Re: DAV Building (H19-D23)

Re: DAV Building (H-19-D23) Dated - 12/17/82

DRAINAGE REPORT AND DRAINAGE PLAN CHECKLIST

DRAINAGE PLAN - 2511 UTAH ST., NE

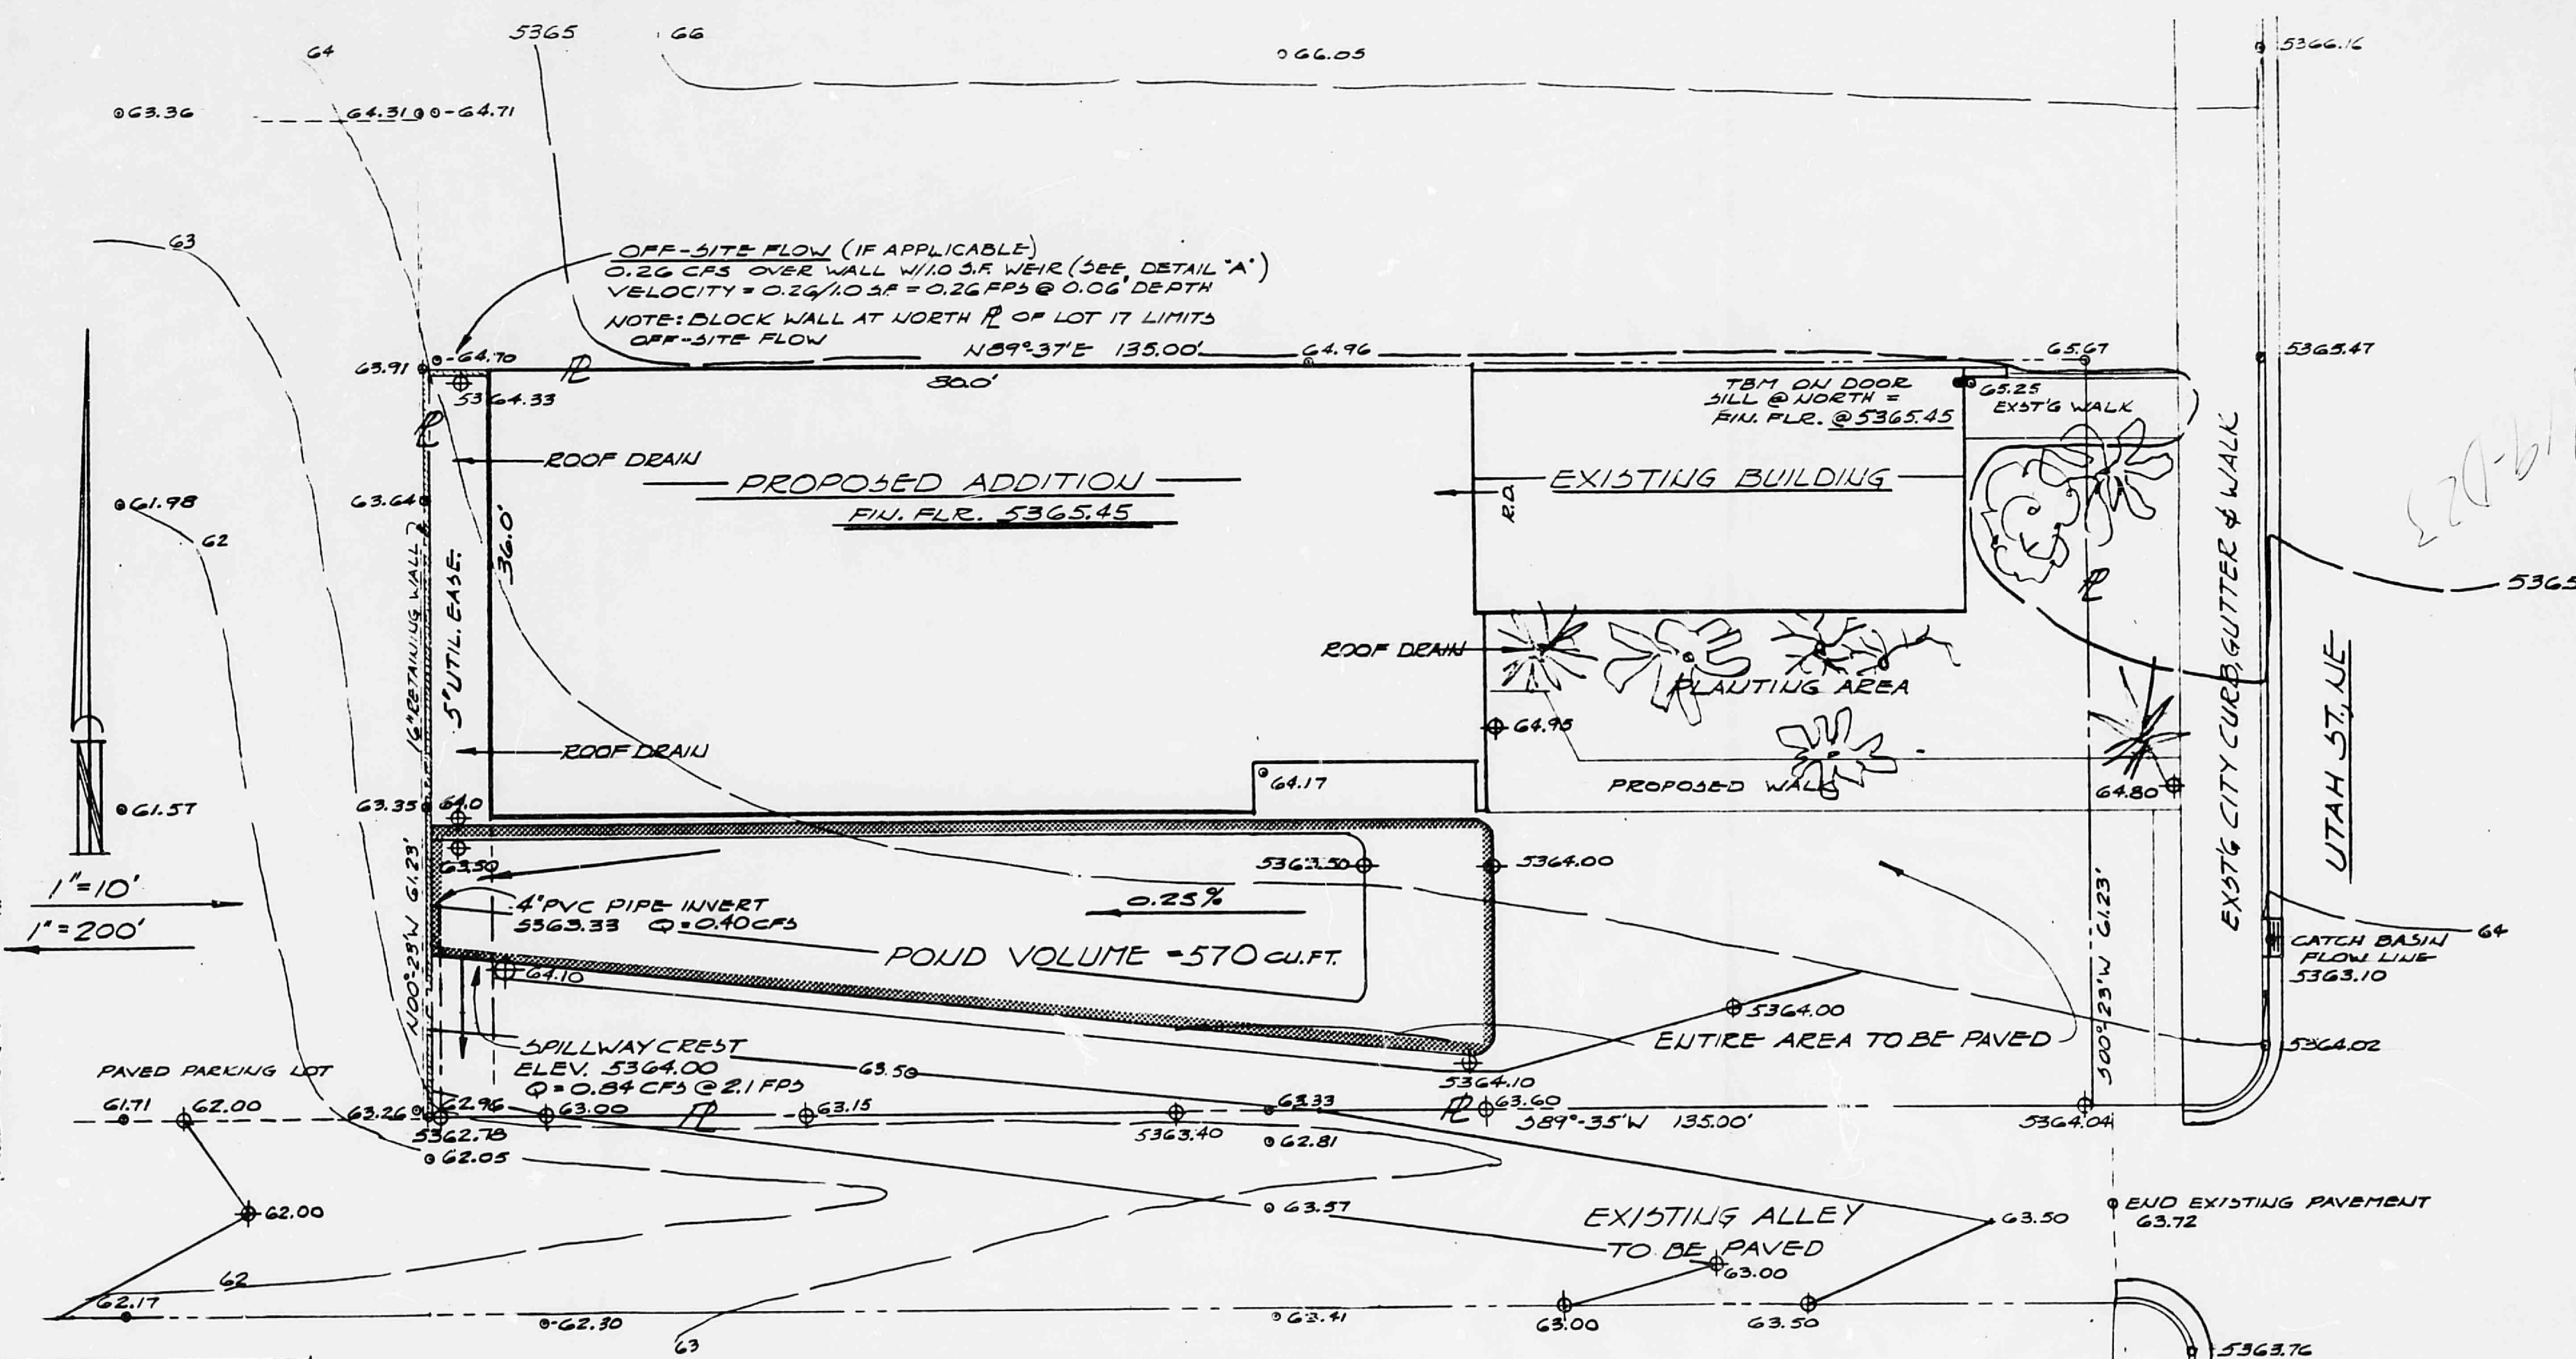
of the unimproved alley to convey the proposed storm runoff with respect to erosion and existing drainage pattern. Item 15, 17.A.1.&2. - Unable to follow the calculations provided for the required pond volume. Provide units and reference the values used in the calculations.

Note: The ponding requirements are not based on the difference between the developed and undeveloped flow rate but is based on the allowable discharge rate from the developed site.
